ASSESSMENT REPORT

Central Park - Block 8 SSD 6092 MOD 2

DWG TITLE
BASEMENT 3 FLOOR PLAN
DWG NO
DA:100
REV
D5

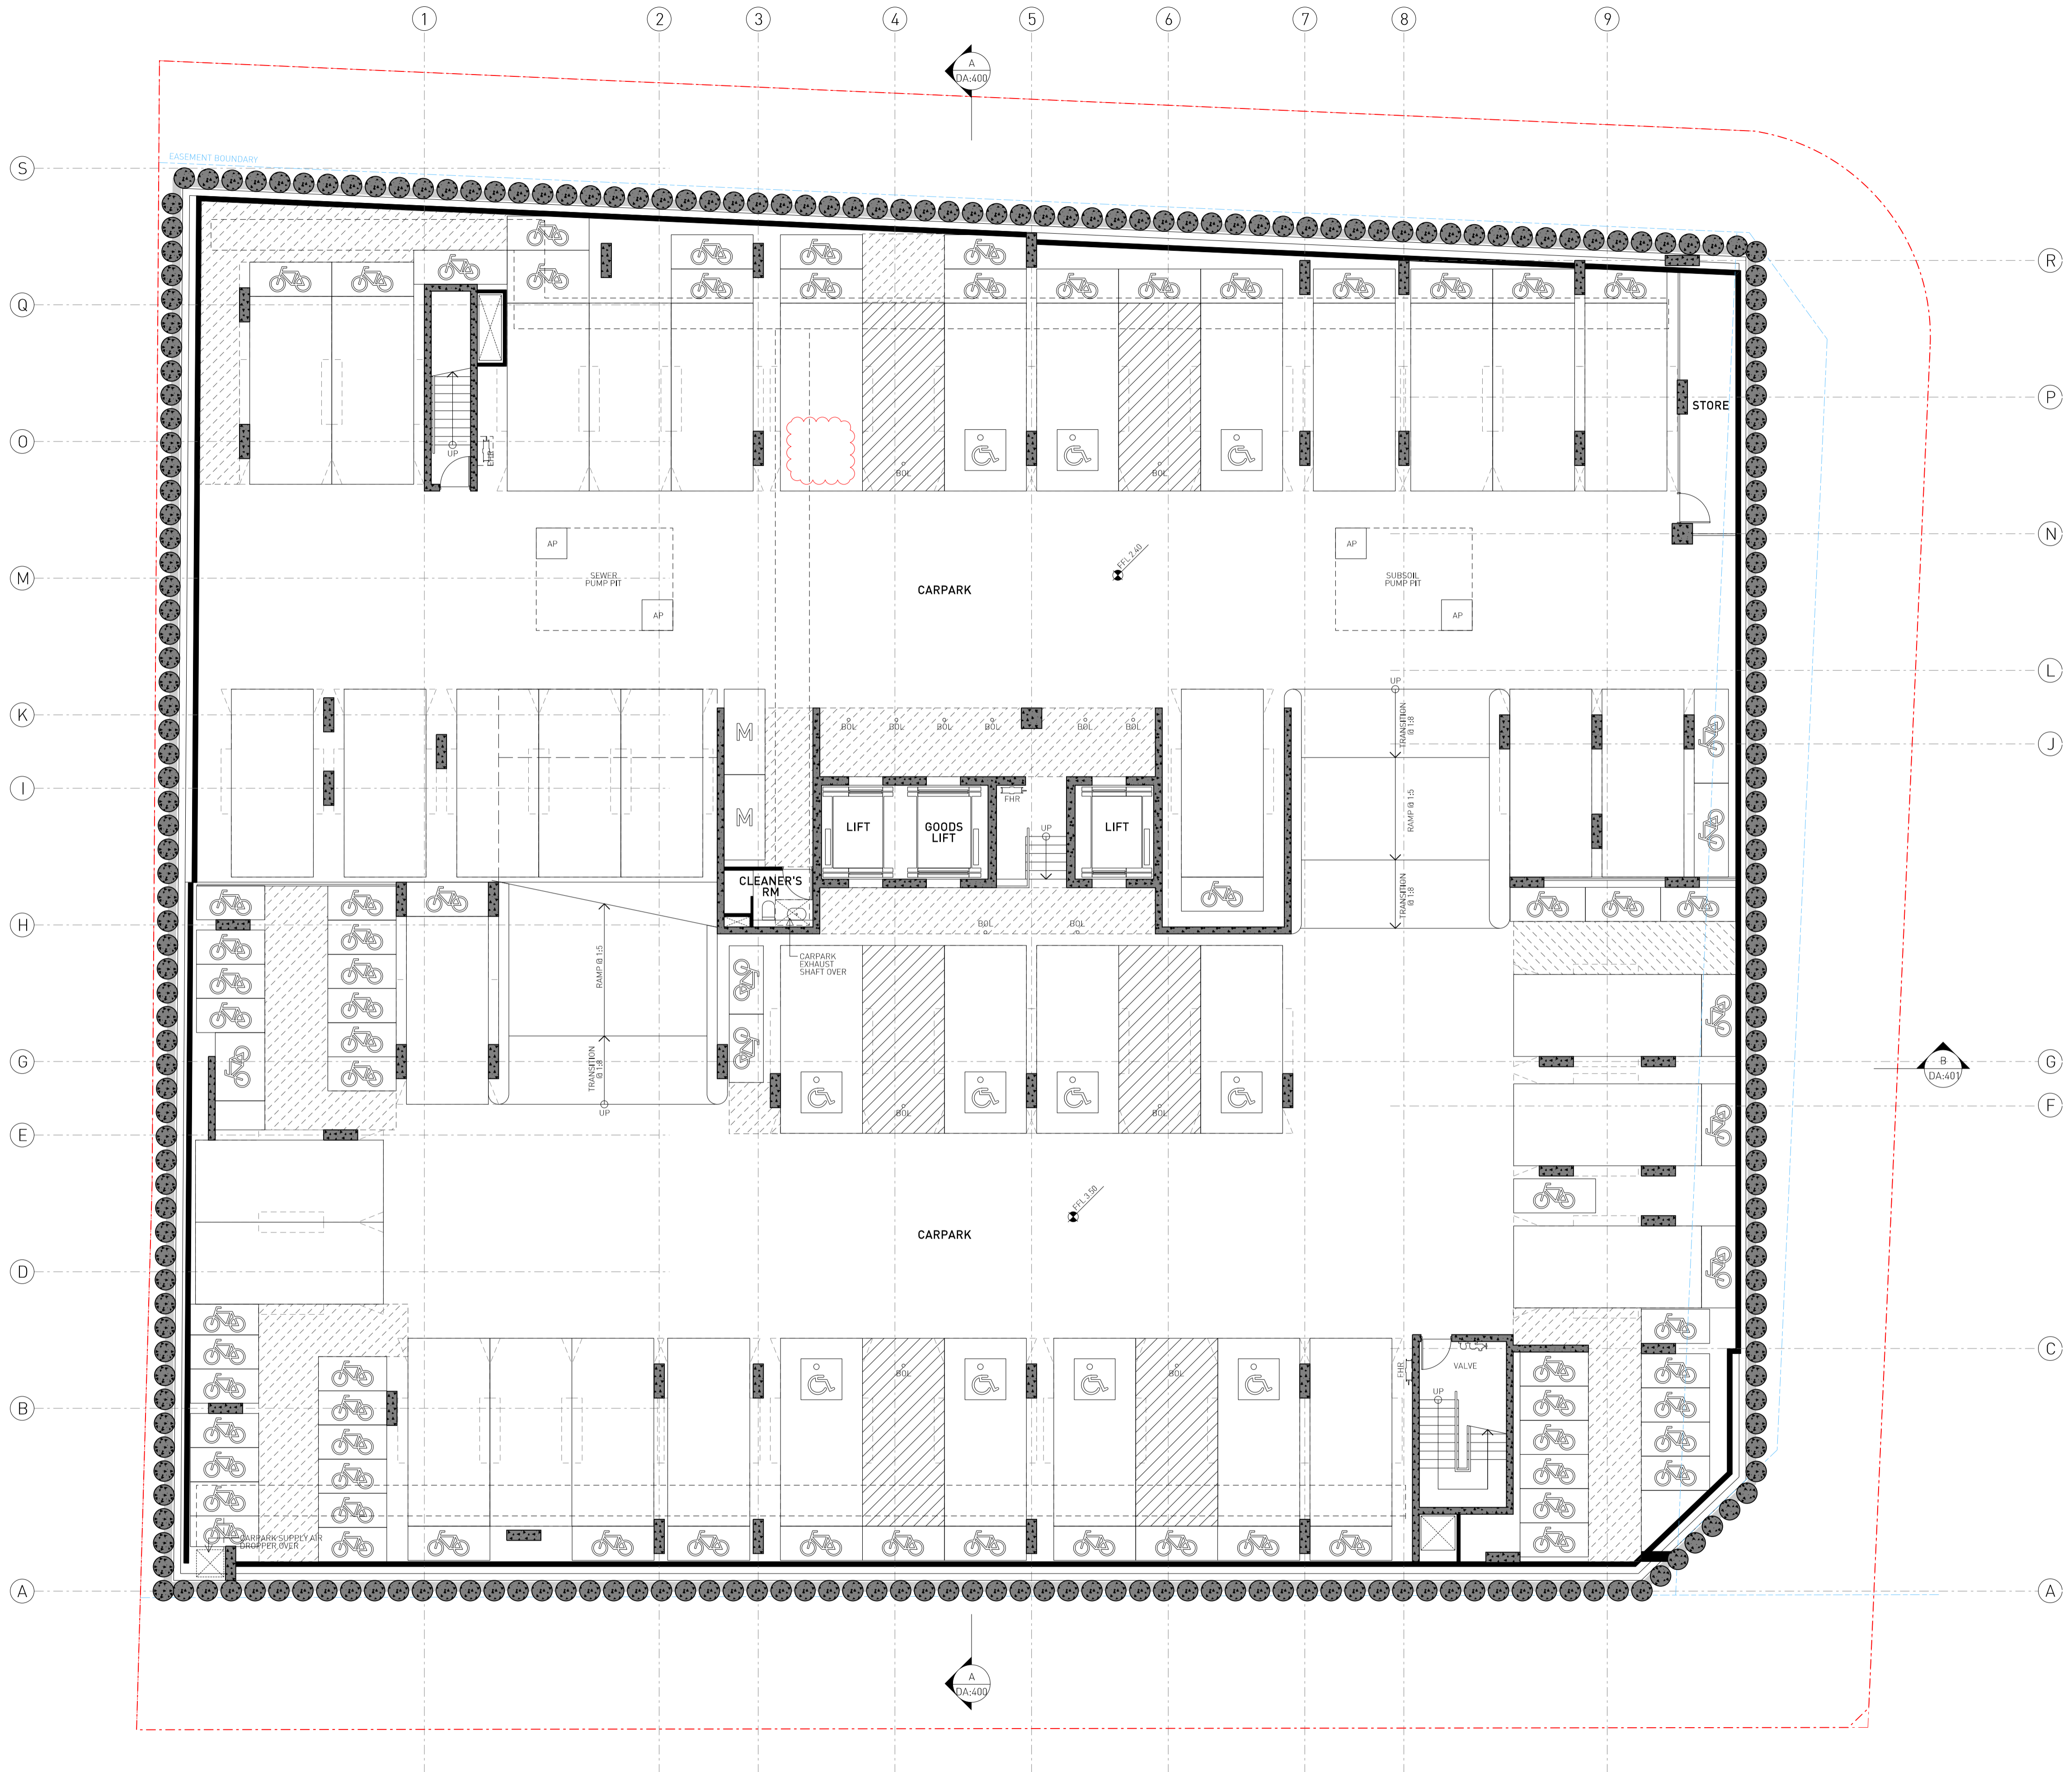
Council advised it did not support the application without the submission of amended plans, as the proposed modification to Condition B21(a) would result in an inconsistency with the number of accessible spaces shown on the approved plans (28) and the number sought in the condition (27).

In response, the Applicant submitted an updated basement plan to reflect the requested modification.

The Department referred the updated plan to Council and no response was received. However, the Department is satisfied the updated plan addresses the issue raised by Council.
